Comments for Planning Application 23/01441/FUL

Application Number: 23/01441/FUL

Address: Orchard West Theatre Land To The East Of Orchard Street, West Of Hythe Street
Dartford DA1 1BX

Proposal: Temporary theatre including auditorium, foyer, bar area, box office, toilets, stage, backstage and storage (Sui generis); together with associated servicing area; external waste storage, above ground fuel tanks, external heaters and power generators; pedestrian ramps (for external Stage Door and Fire Exits); alterations to and additional asphalt hardstanding; alterations to vehicle access gates on Hythe Street; alterations to means of enclosure to introduce fire escape gates; on-site security (V Mesh) fencing and external lighting (retrospective)

Horizontal Illuminance (lux)

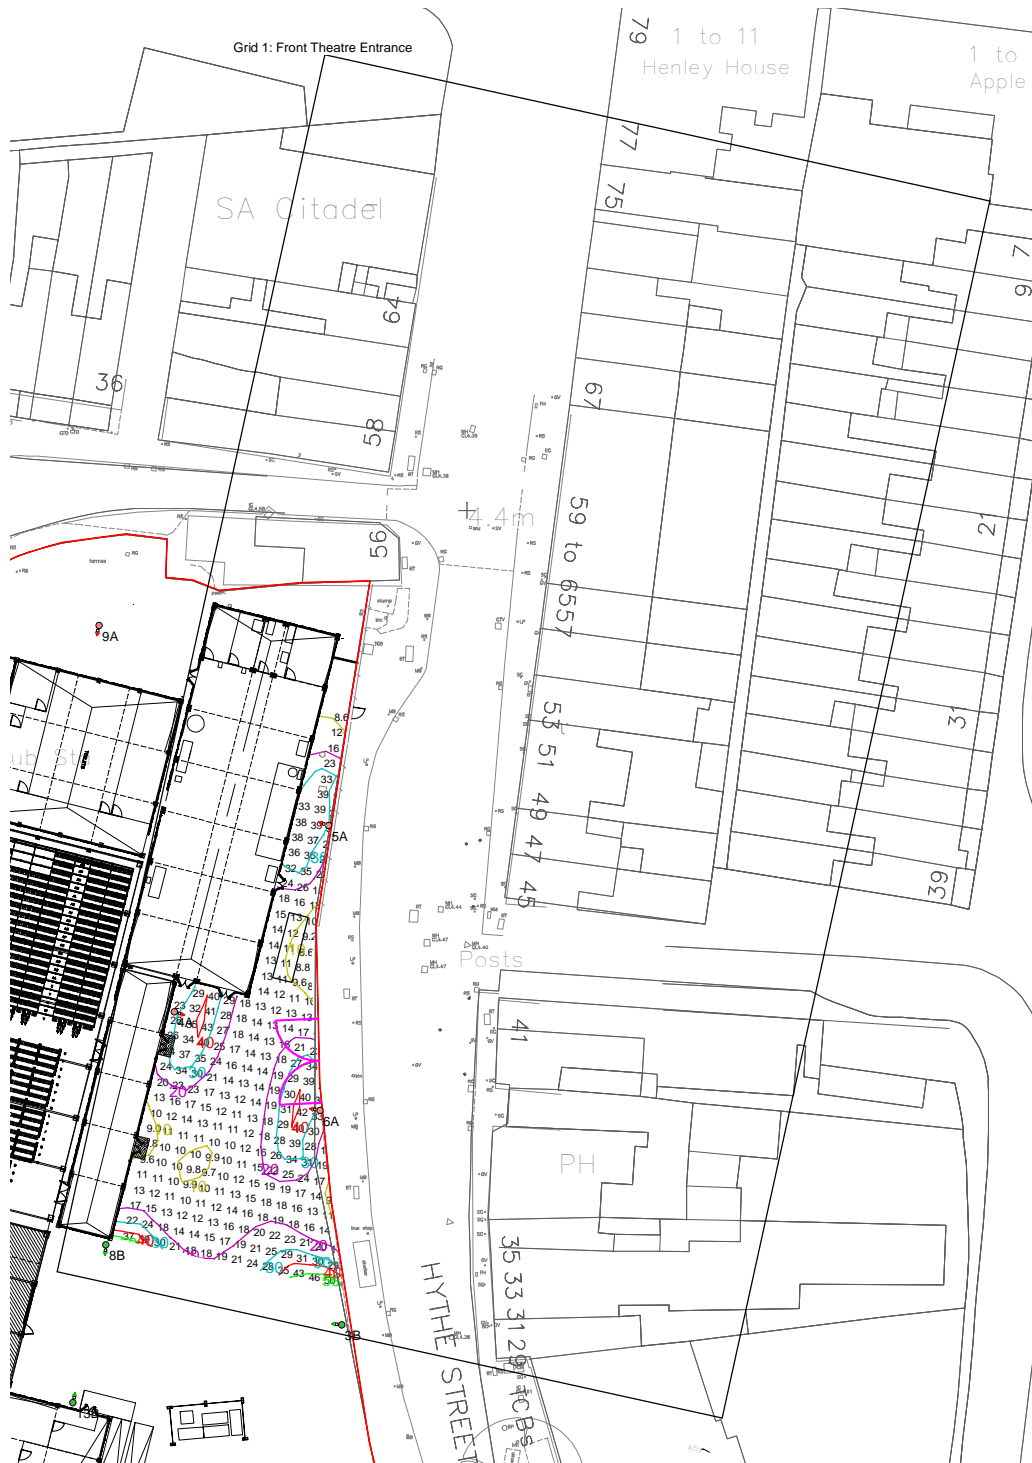
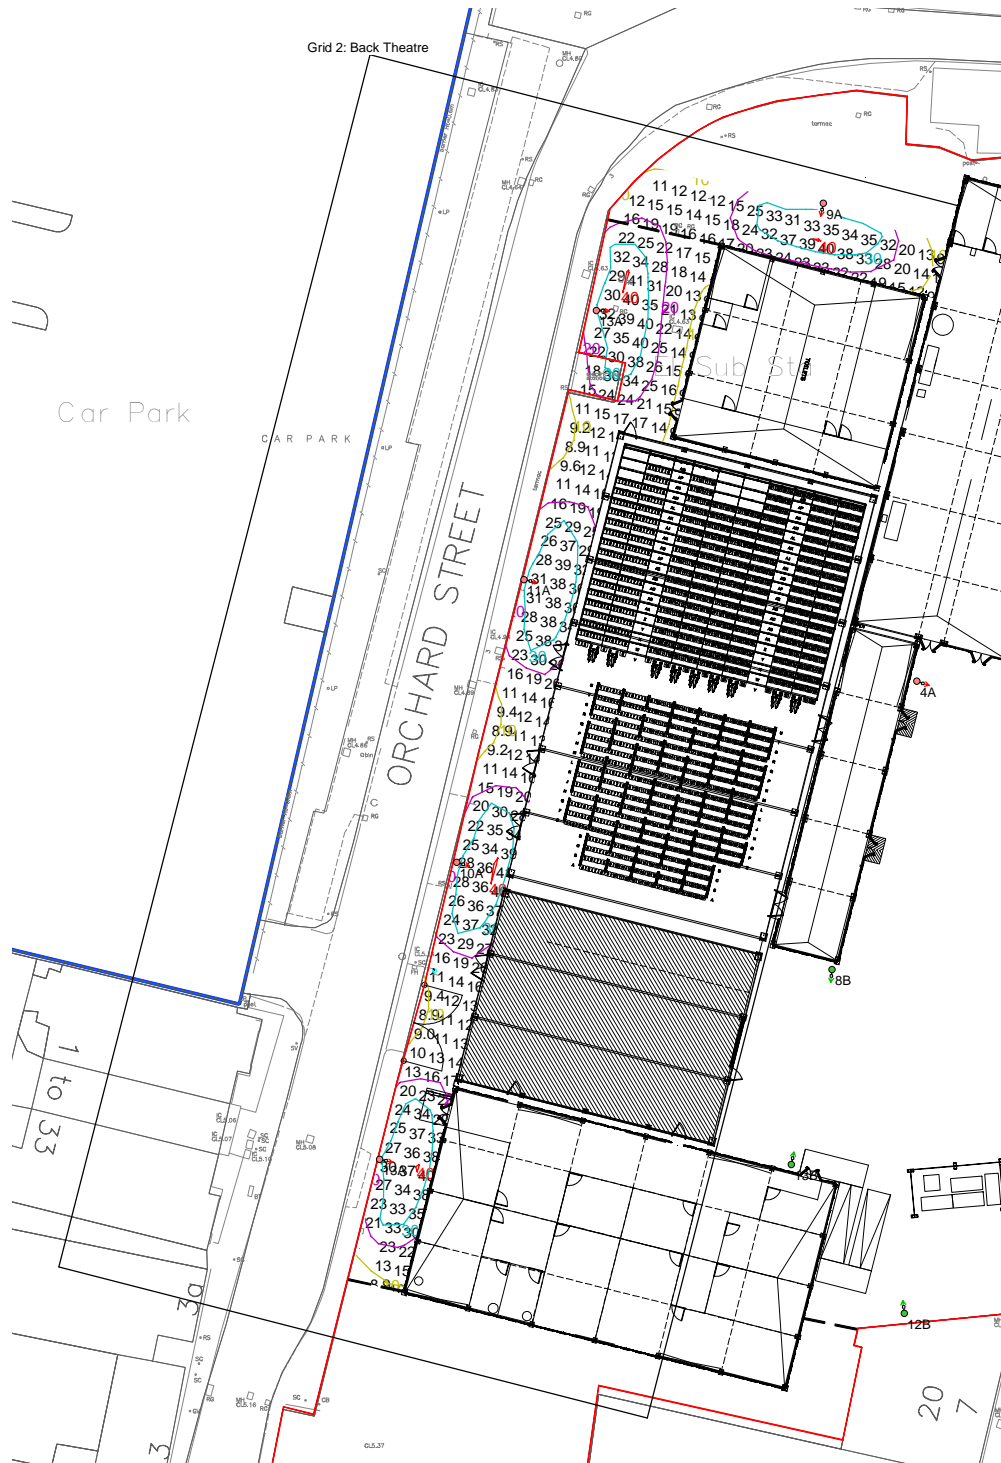
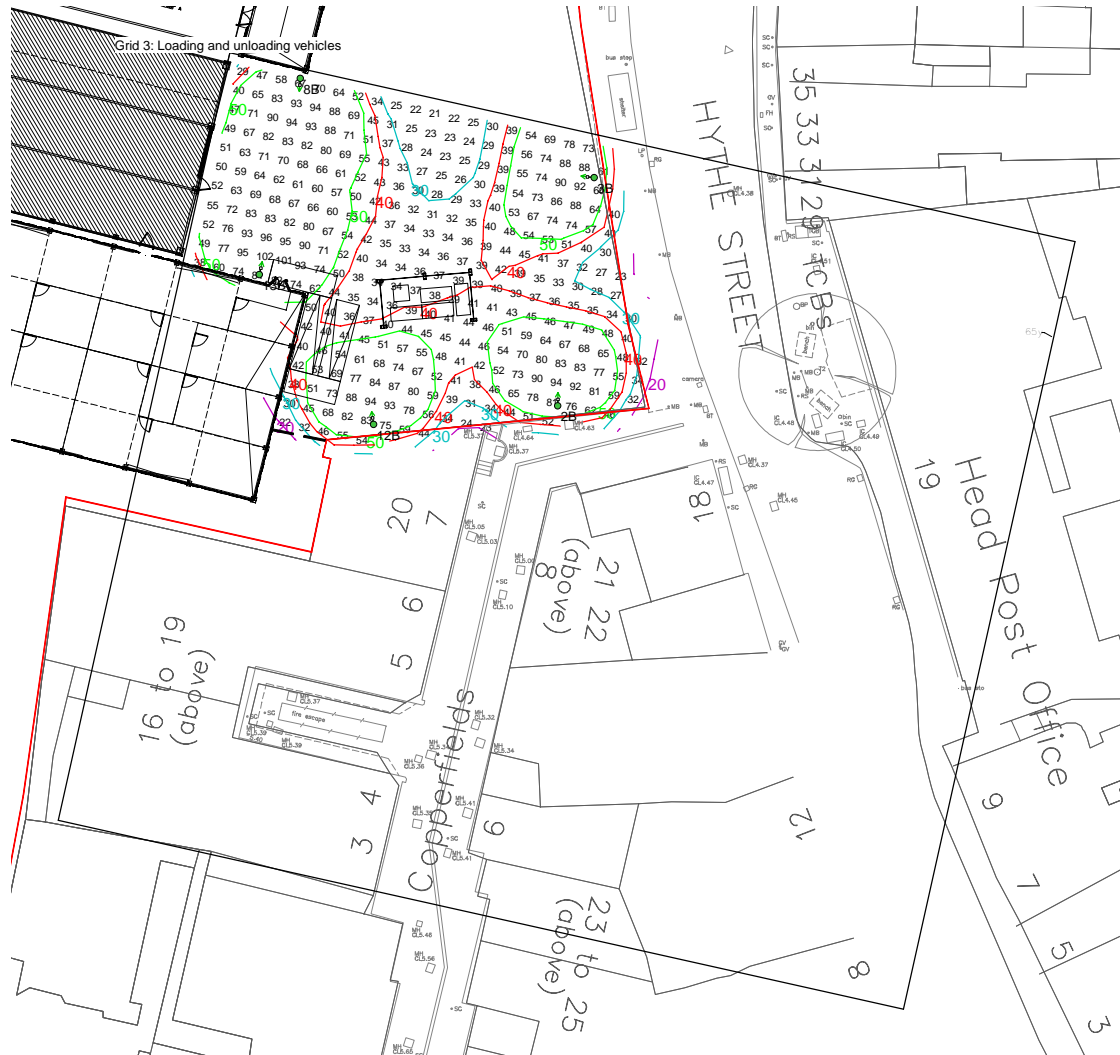
Comment: Can you confirm the timings of the lighting and I cannot work out whether the lights face our house, do they shine in our direction?
